From: Andrew Fuller <andrew@a-fuller.co.uk>
Sent: 15 May 2014 17:33
To: Anita Gardner
Cc: Estella Wood
Subject: 12 High Street, Arundel, LBC

Drawing Name
Plans - Existing

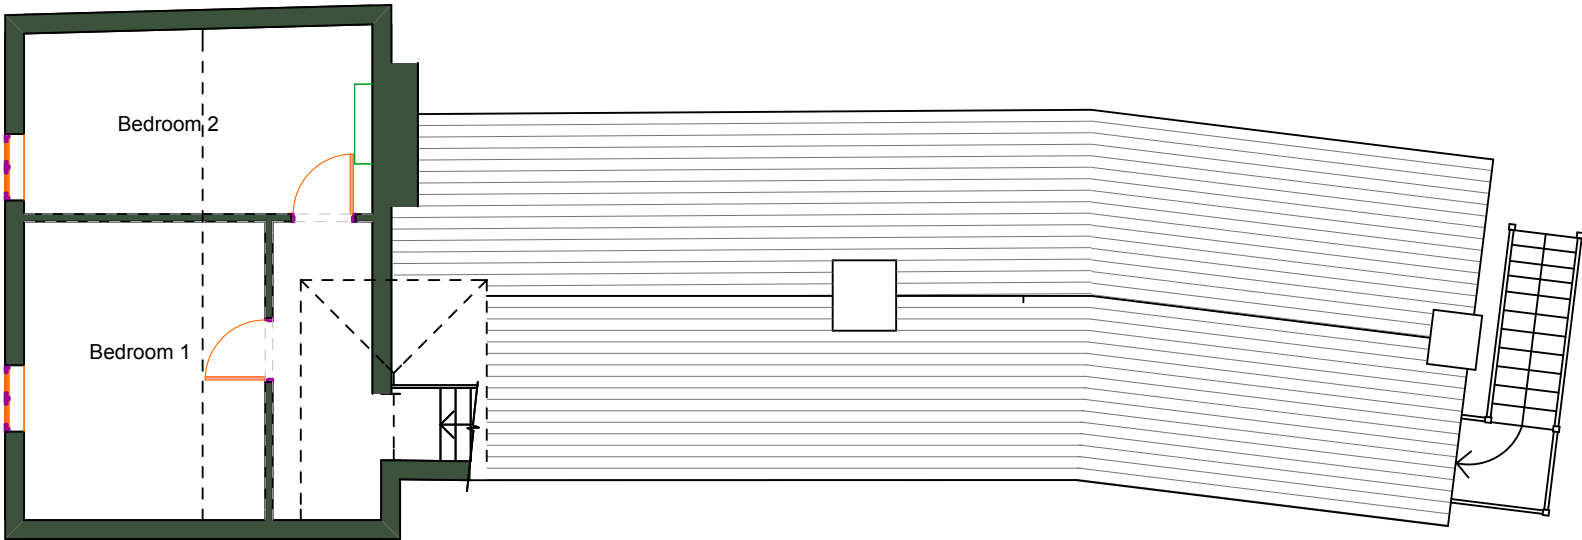
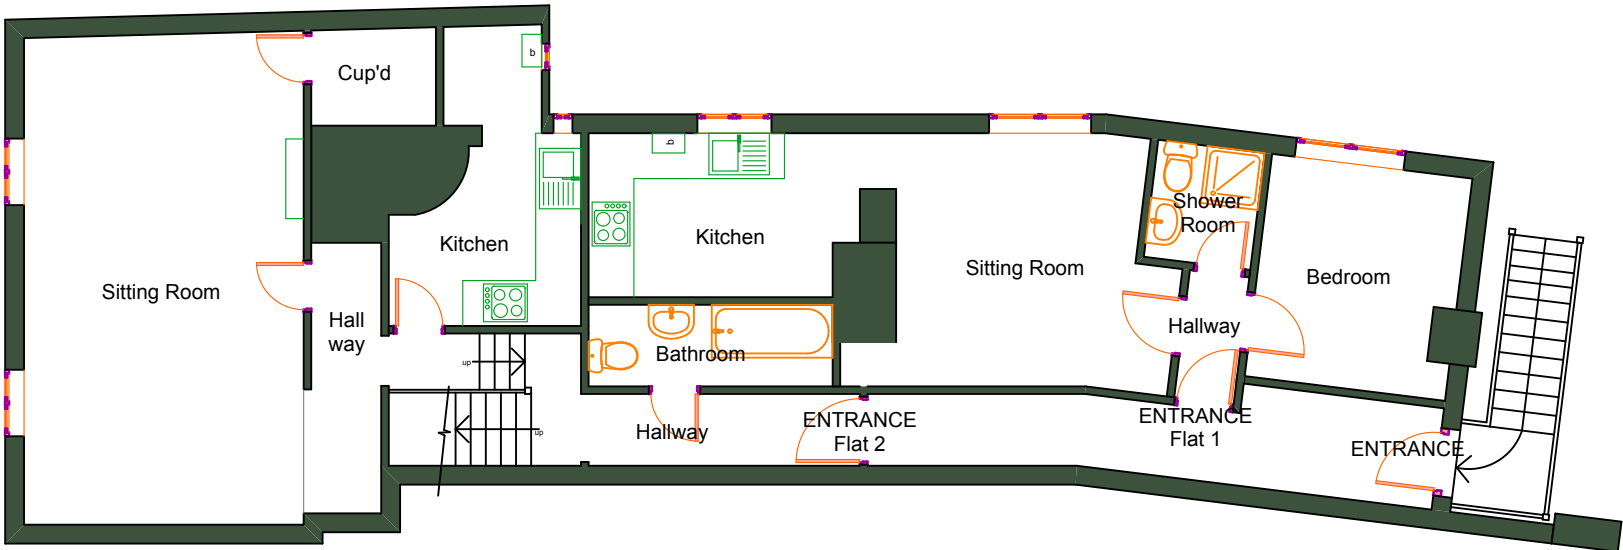
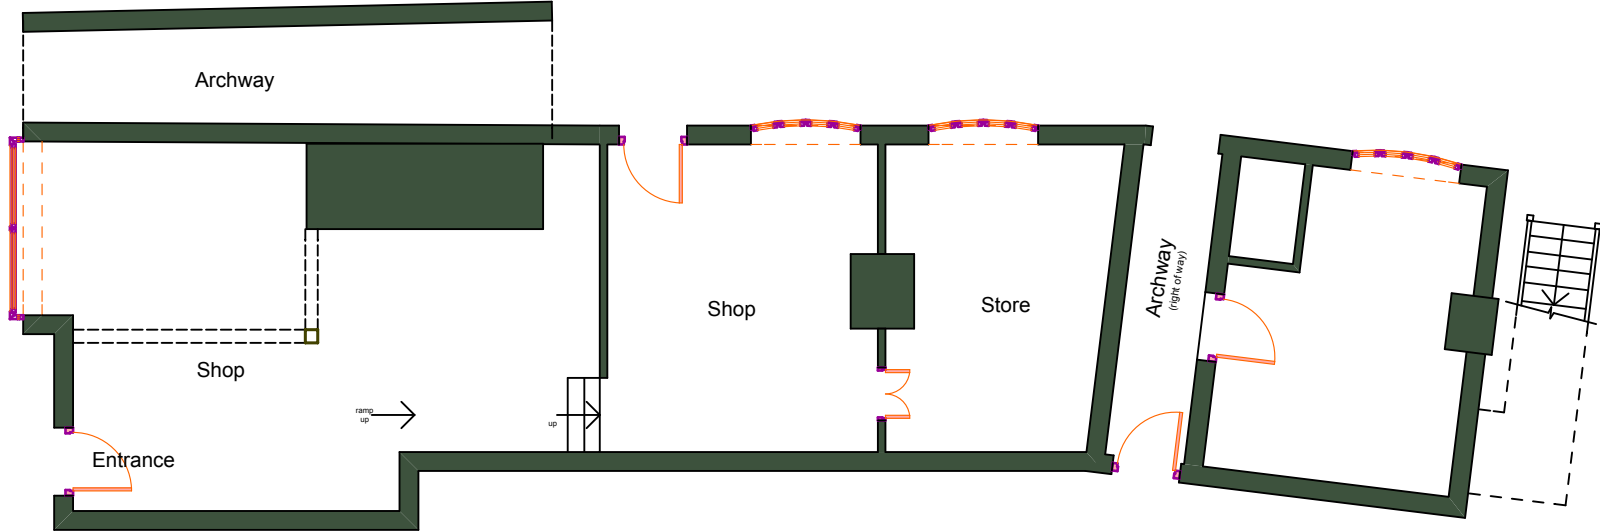
I attach a picture of the modern double doors in the wall we were talking about.

It shows on the "existing" drawing, and I am unsure if this requires retention therefore of a nib of the wall. Much of the historic evidence is already lost? Please let me know if you would prefer to retain a little piece, and I will insert a door the other side as agreed, in the morning.
